May 7, 2019

RE: *Hale Sand Pit*
 PCD File No. AL1829, PPR 1914
 Site Development Plan and Special Use Permit Resubmittals

Thank you for the comments on April 23, 2019 for the above-mentioned project. In an effort to address your comments concisely and simplify your review of the Hale Sand Pit, we have summarized your comments and our responses below.

**EXHIBIT C - PRE MINING PLAN MAP**  
03/25/2019

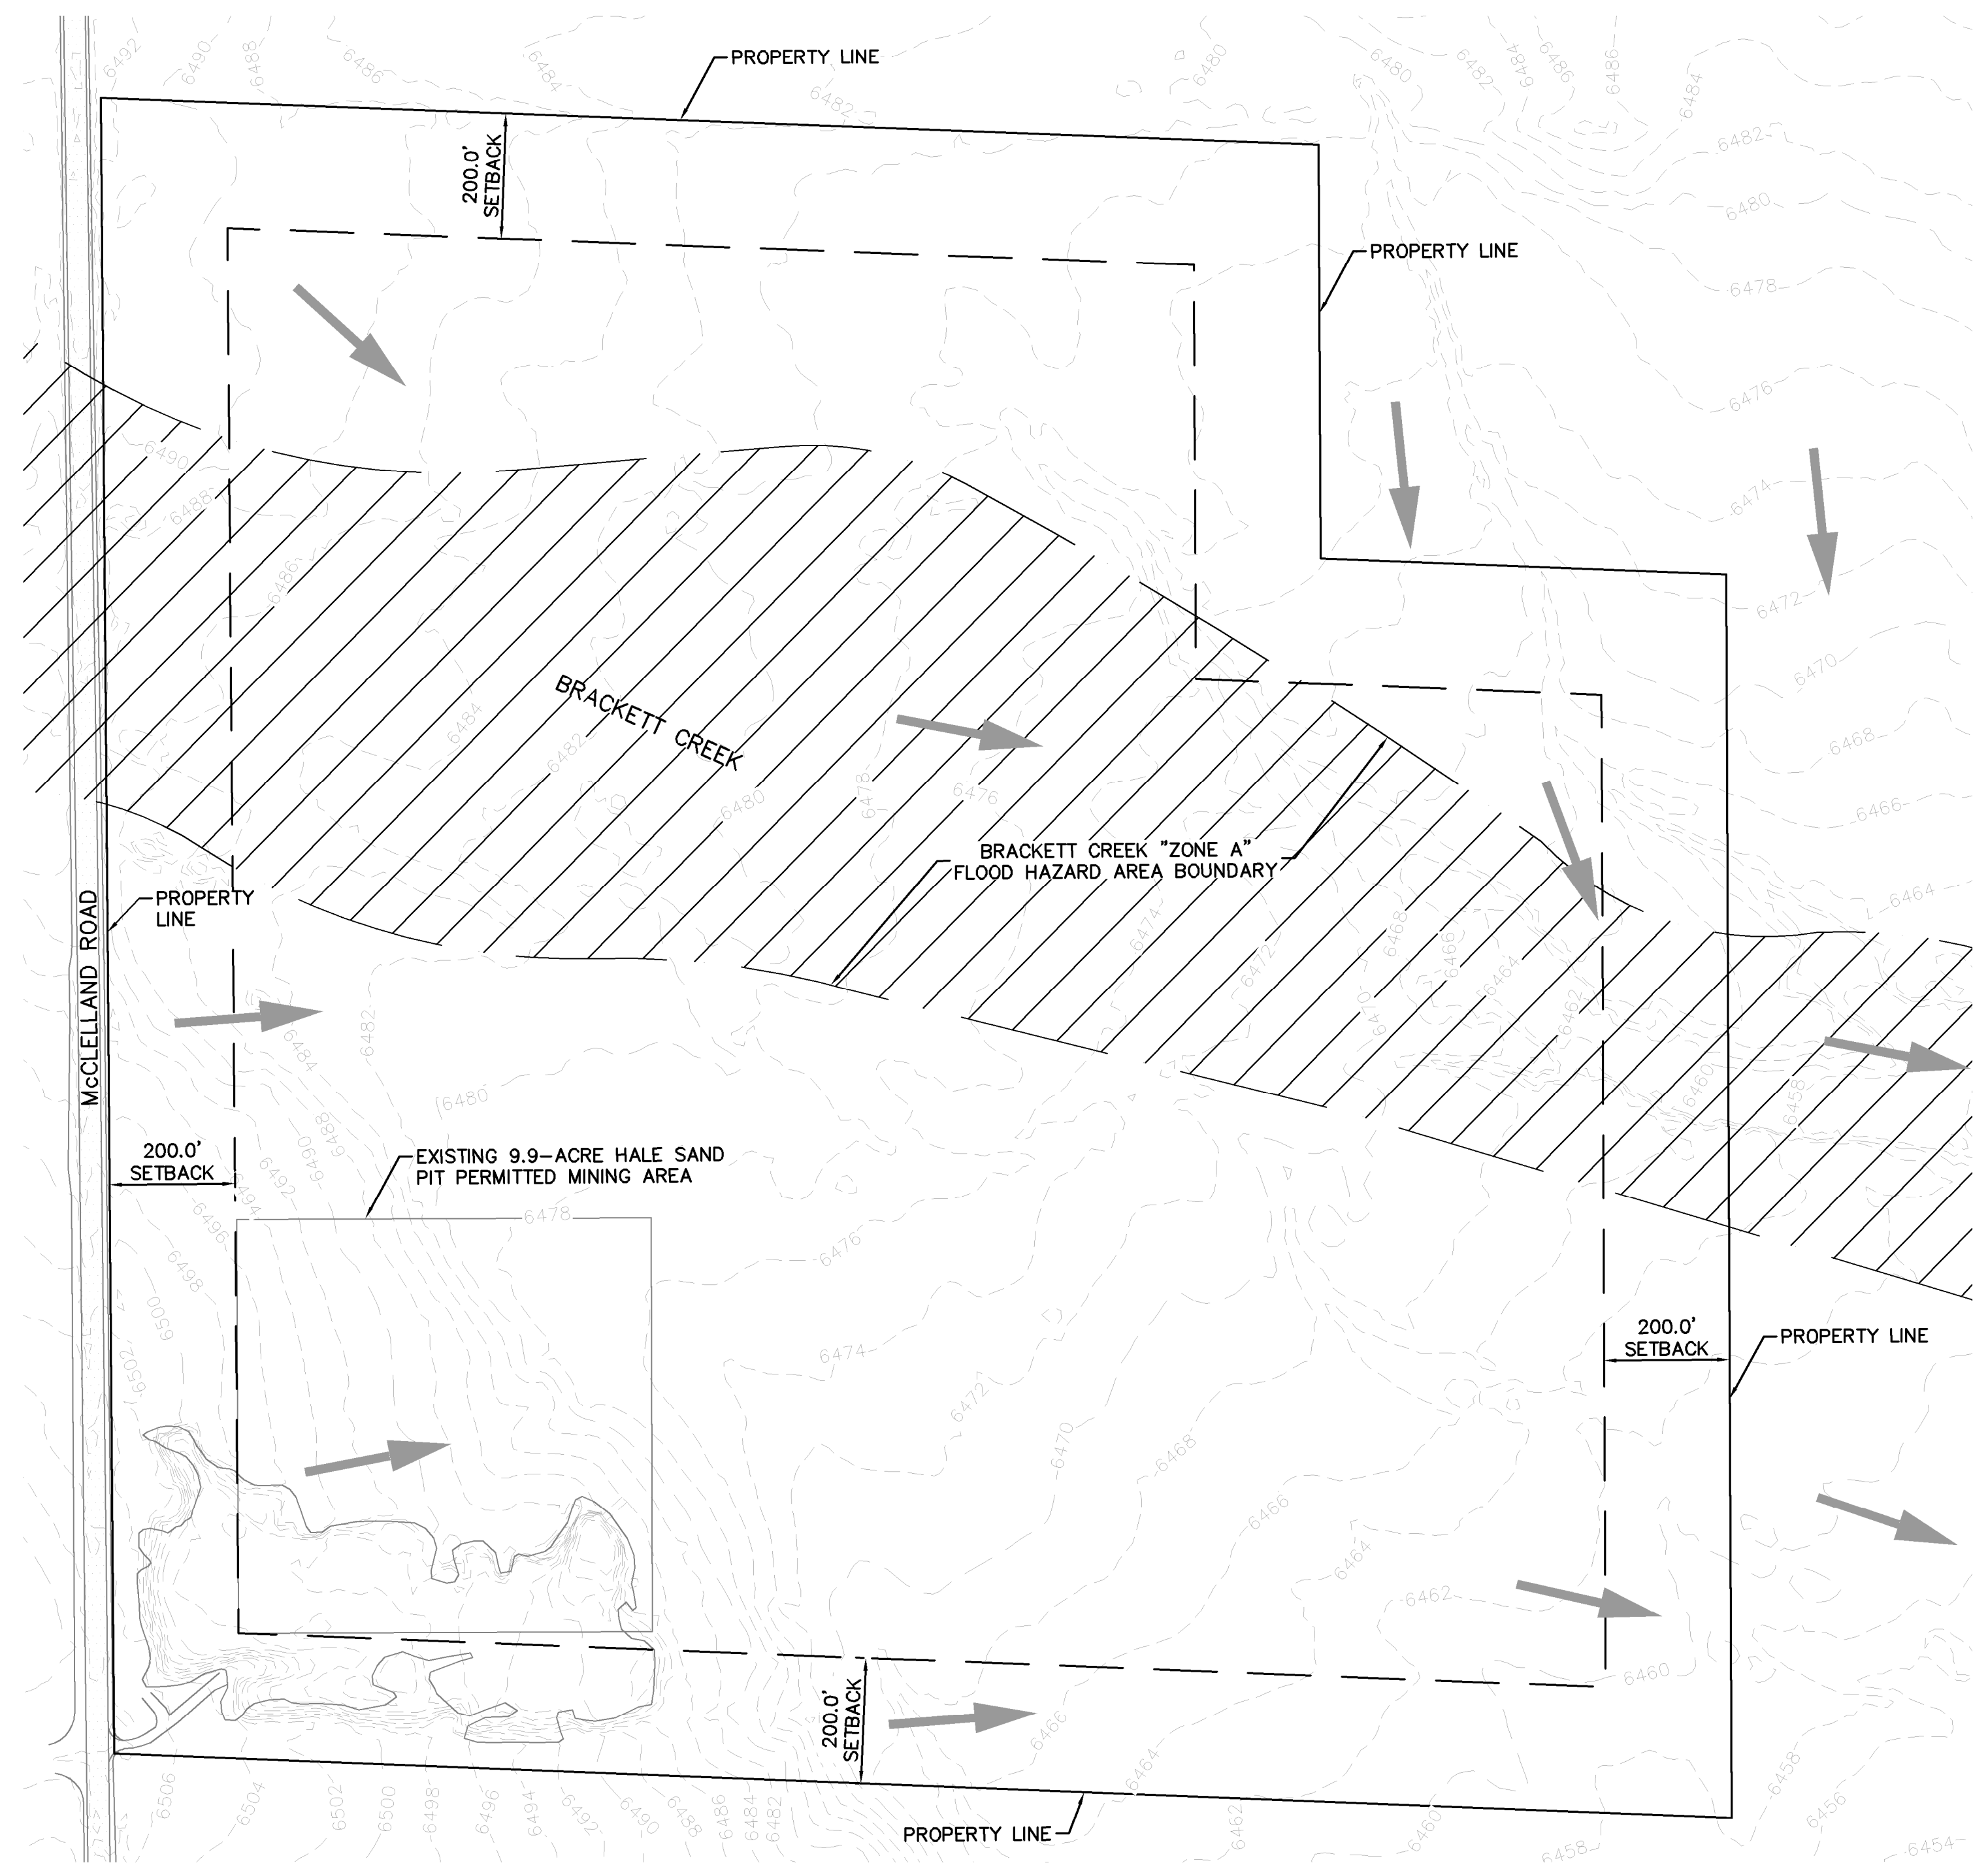
1. (Exhibit C, Pre-Mining Plan Map) Please update the FEMA Firm panel number.
 - *Response: The FEMA Firm panel number was updated.*
2. (Exhibit C, Mining Plan Map) Please update the FEMA Firm panel number.
 - *Response: The FEMA Firm panel number was updated.*
3. (Exhibit C, Mining Plan Map) Flow arrow does not appear correct based on the proposed contours.
 - *Response: The flow arrow was updated to match the proposed contours.*
